SUBJECT: REZONING PETITION 2008-081

REZONING PETITION 2008-081
NEIGHBORHOOD MEETING MINUTES
JULY 8, 2008

ILLUSTRATIVE SITE PLAN
SCALE= 1:50

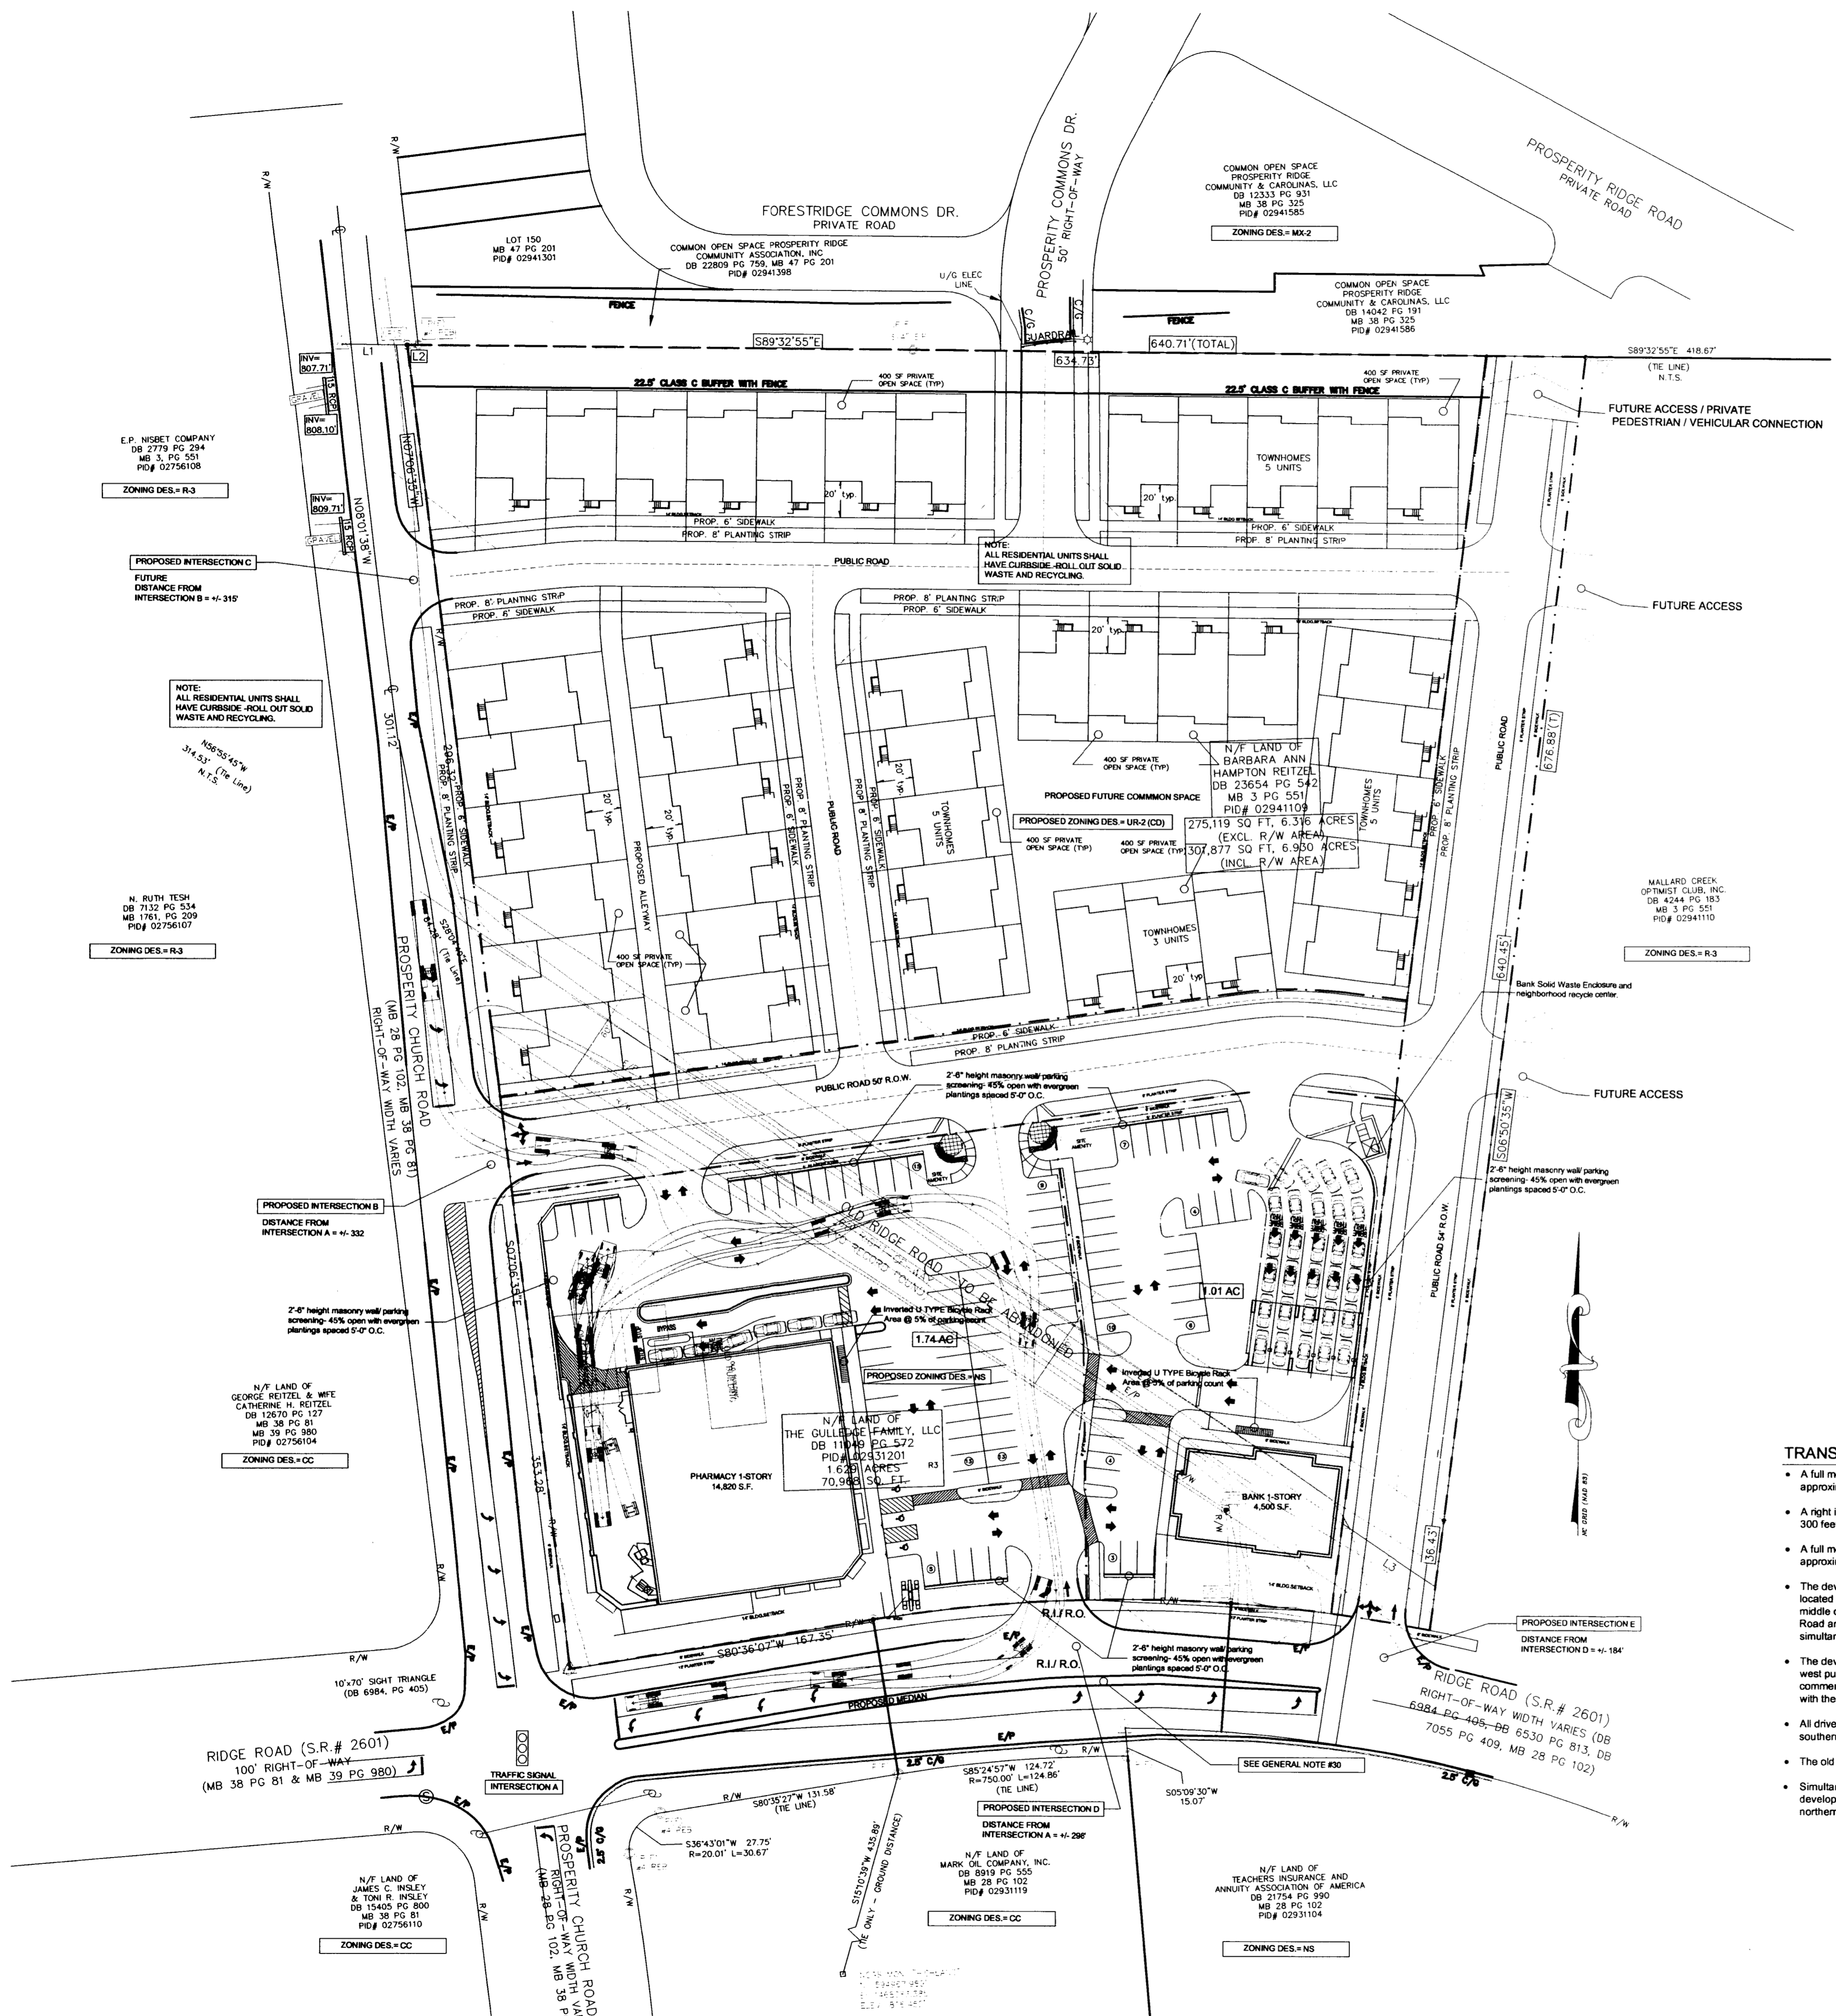
1. Michael Aufrecht representing the Northeast Coalition of Neighborhoods requested that we add a note to the rezoning petition stating that the exterior building materials for the townhomes be primarily a combination of brick, hardiplank and dryvit. He requested that vinyl siding not be permitted for the majority of the exterior elevations, but that a minimal amount of vinyl siding would be allowable if used in areas such as eaves and soffits. The petitioner agreed to add this note.

2. Al Gulla representing the neighborhood association of Prosperity Ridge requested that we modify the note on the plan that calls for the installation of speed bumps in the streets being built in conjunction with the townhome portion of the development also include speed bumps on Prosperity Commons Drive. The installation of any speed bumps would be subject to CDOT approval. The petitioner agreed to make this modification to the existing note.
